REVISIONS:
A 02.09.19 Window added to bathroom.
B 11.11.19 First floor extension set back by 500mm as requested by the planners

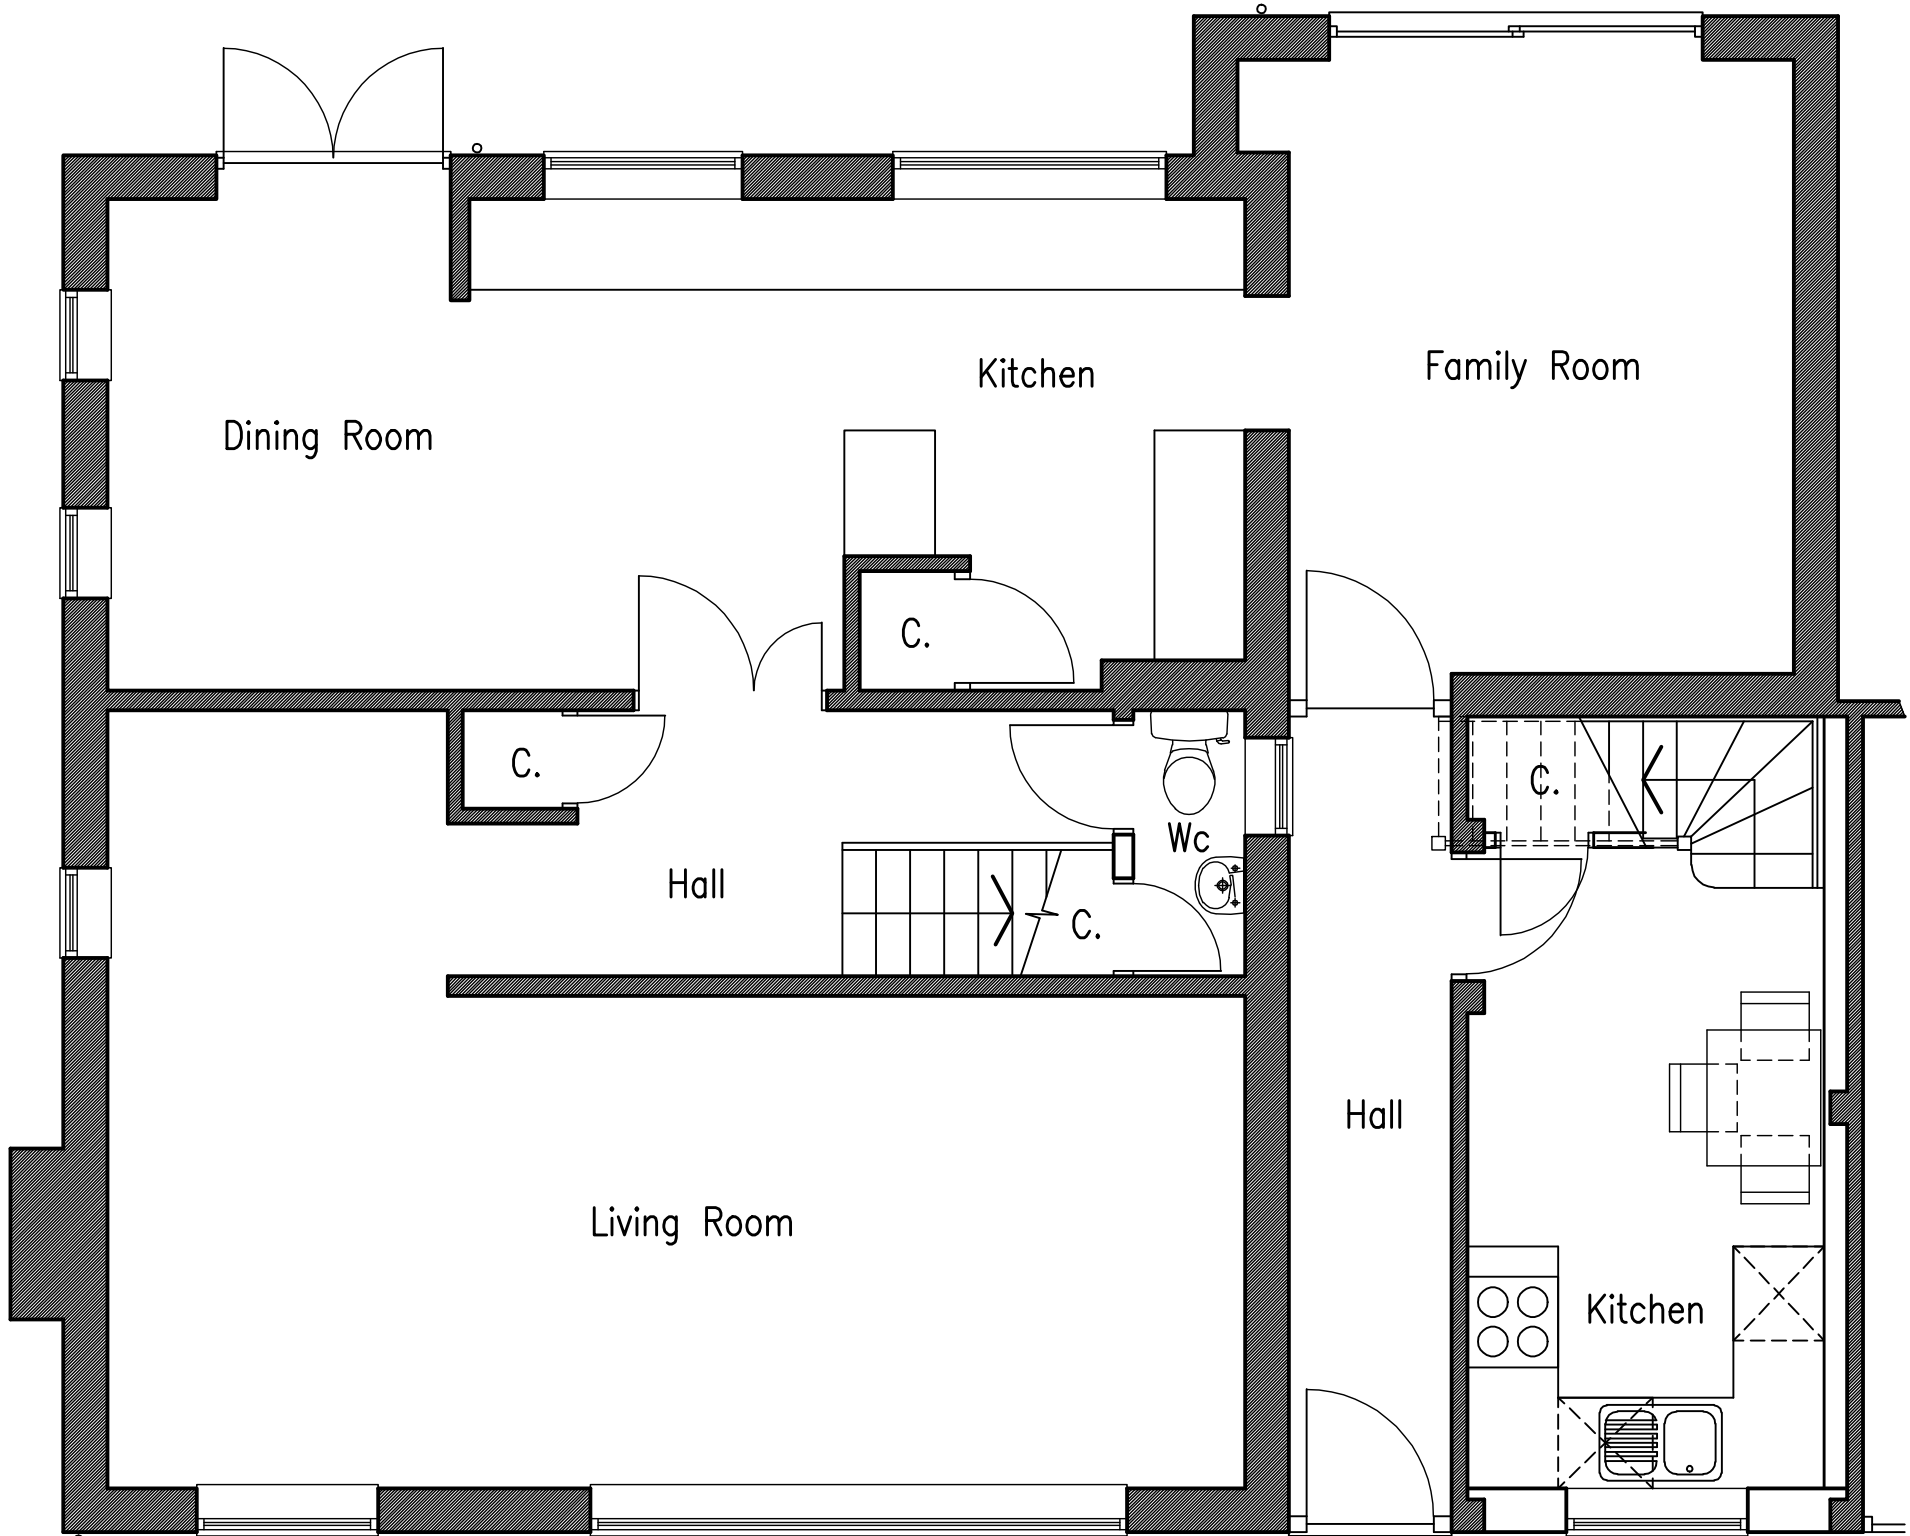
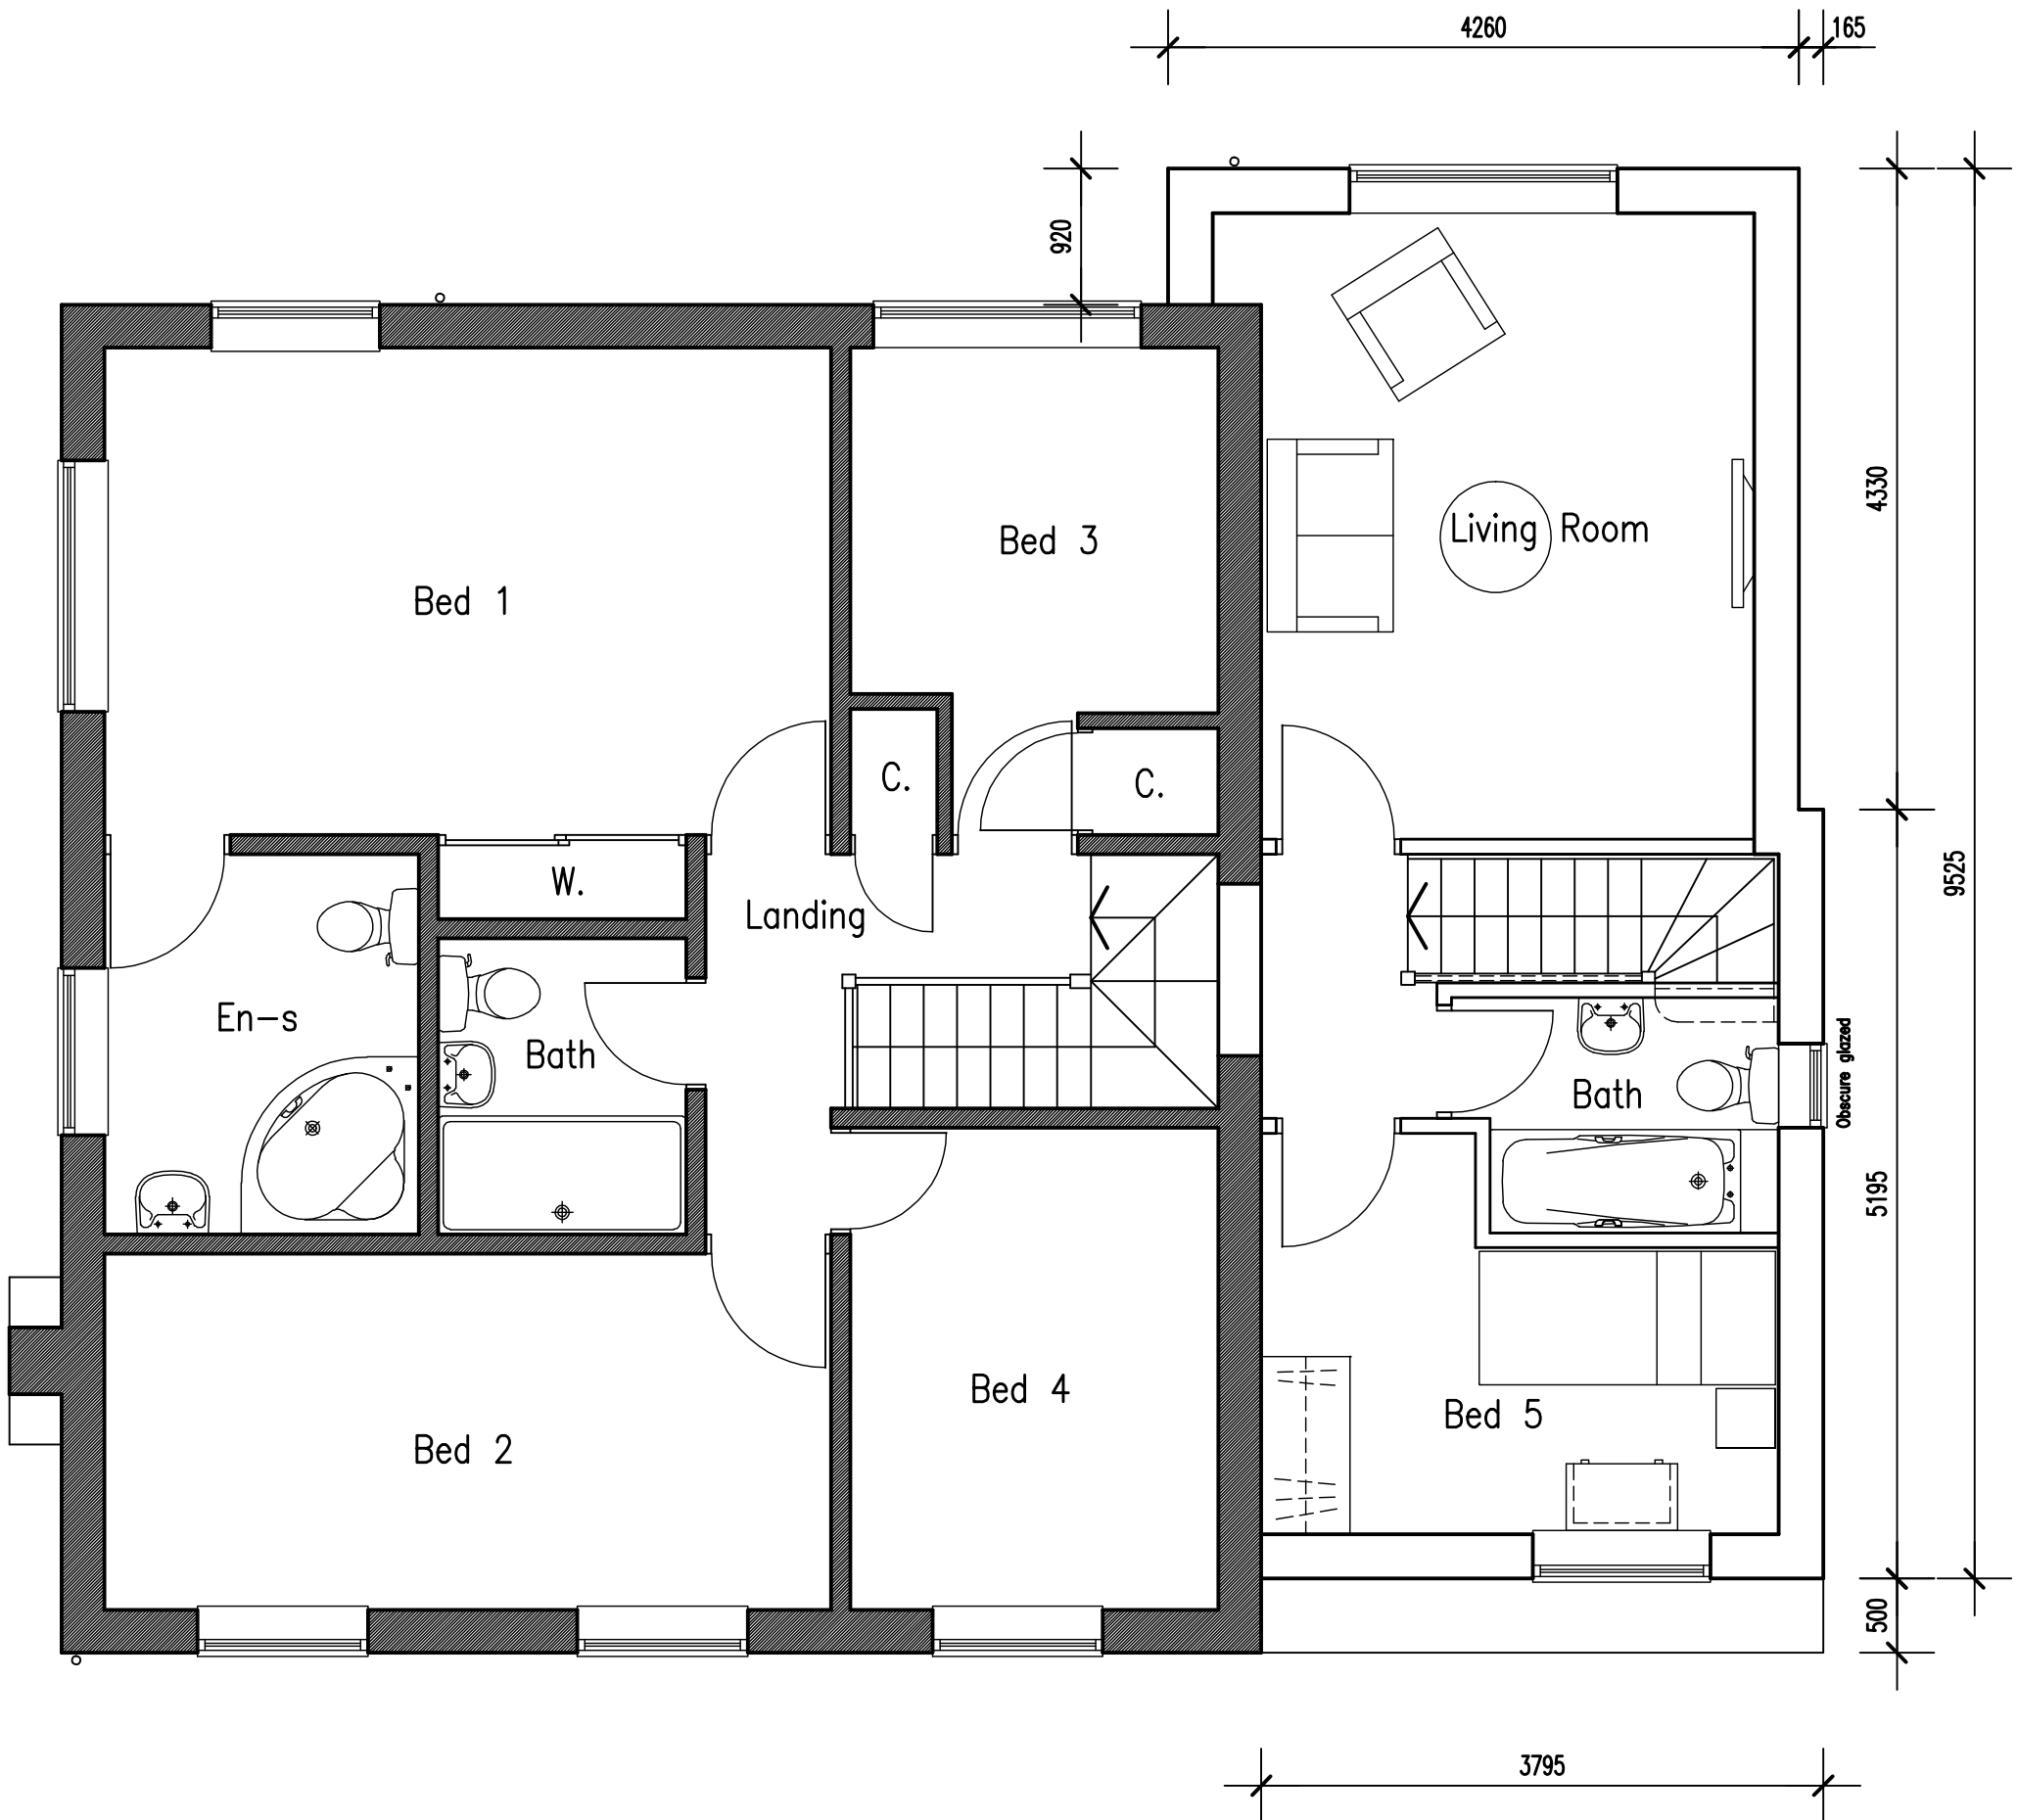
Having spoken to my manager would it be possible to move the proposed frontage of the extension back 0.5m to avoid the possibility of terracing if number 32 decides to do the same? If this is something you can do please send amended drawings so that I can get a decision with you as soon as possible.

Further to your earlier e-mail please find attached amended drawings showing the first floor extension set back by 500mm as requested.
